From: Katherine Rawlins
Sent: 15 February 2013 09:53
To: [REDACTED]
Subject: RE: AW/326/12 5, Elizabeth Ave, Rose Green.

Subject: AW/326/12 5, Elizabeth Ave, Rose Green.

front

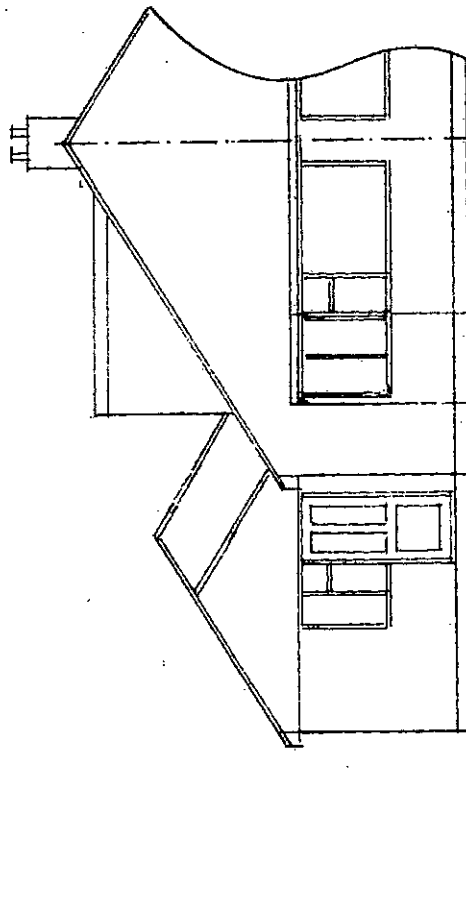
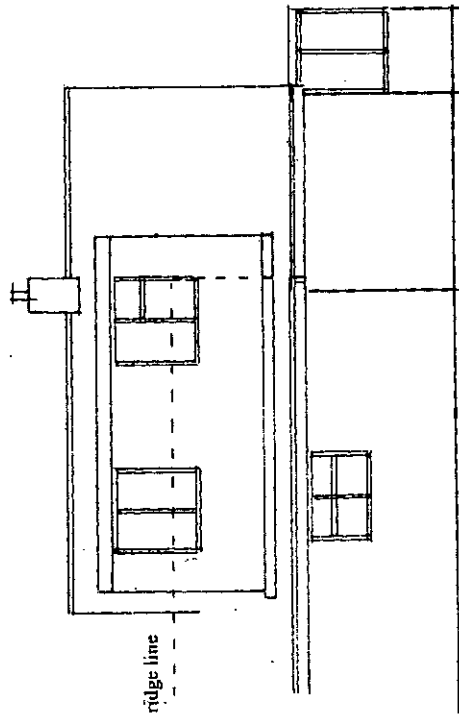
Thank you for the amended elevations to show the revisions to the proposed dormer.

There is no objection in principle to a dormer, but the main concern is with the size and bulk.

The reduced width and depth is an improvement from the refused scheme. I would therefore suggest that you re-submit the application on the basis of the revised scheme.

I have therefore moved the dormer 600mm further into the roof slope and set it back from the front a further 1100mm providing a total setback of 2.00 metres from the front gable.
